Re: Sandia Mechanical Office Warehouse
2731 Vassar PI NE
Traffic Circulation Layout
Architect's Stamp 12-01-23 (G16-D082B4)

Based upon the information provided in your submittal received 12-13-23, the above referenced plan cannot be approved for Building Permit until the following comments are addressed:

## TRAFFIC CIRCULATION LAYOUT

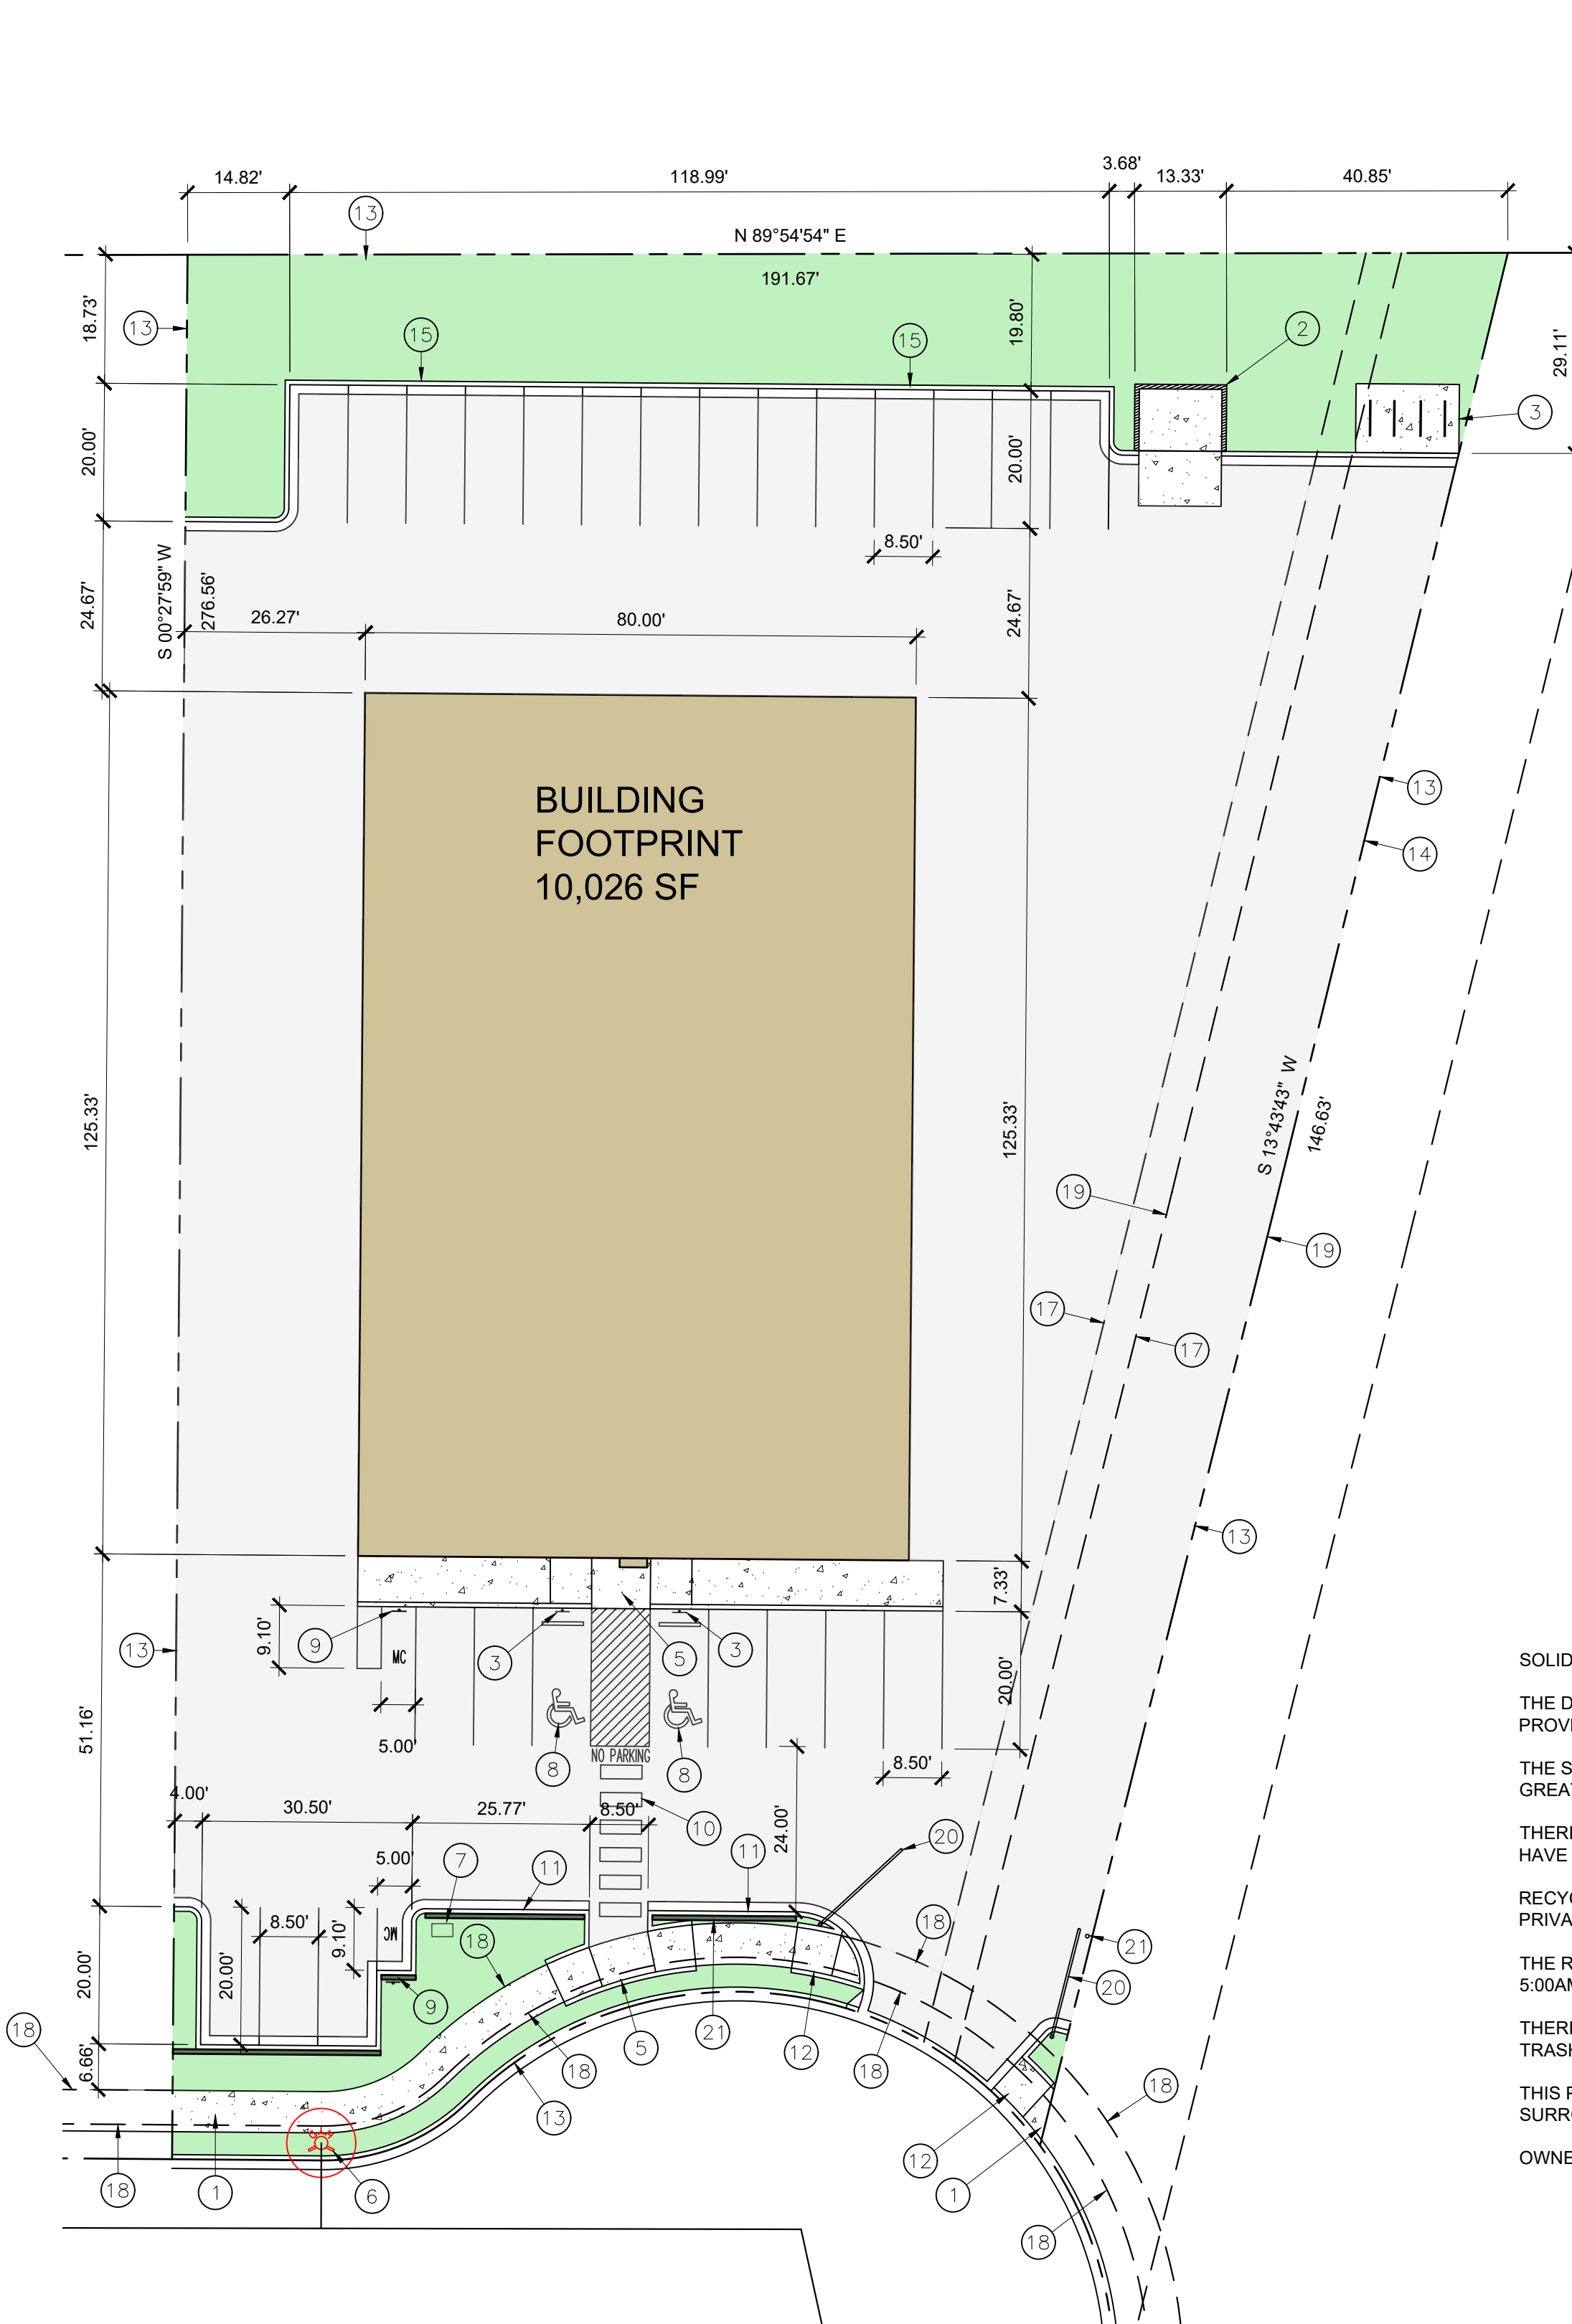
1. Please identify all existing buildings, doors, structures, sidewalks, curbs, drive pads, wall and anything that influences the parking and circulation on the site.
2. Identify all existing access easements and rights of way width dimensions.
3. Identify the right of way width, medians, curb cuts, street widths and street name on Vassar.
4. Provide the width of the site access/entrance. Maximum access width for arterial, collector, and local streets are as follows:

5. Show the location/details of main entrance to the building.
6. Provide the copy of solid waste approval.
7. Remove the trash enclosure details from the plan.
8. The keynotes 4 and 16 are not shown in the plan. Correct these typo mistakes.
9. Provide the sidewalk easement.

10. Provide the radius shown in the figure.

11. It is not apparent what type of pavement surface is being proposed. A hard driving surface will be required as part of this proposed project for parking area and drive aisles.
12. Provide the hatch legends.
13. The labels for HC sign and motorcycle sign has been swaped in the plan. Correct them.

14. Show the clear sight triangle.
15. It is not clear whether the curb separation between the parking and pathway has been provide or not? Show in the plan.
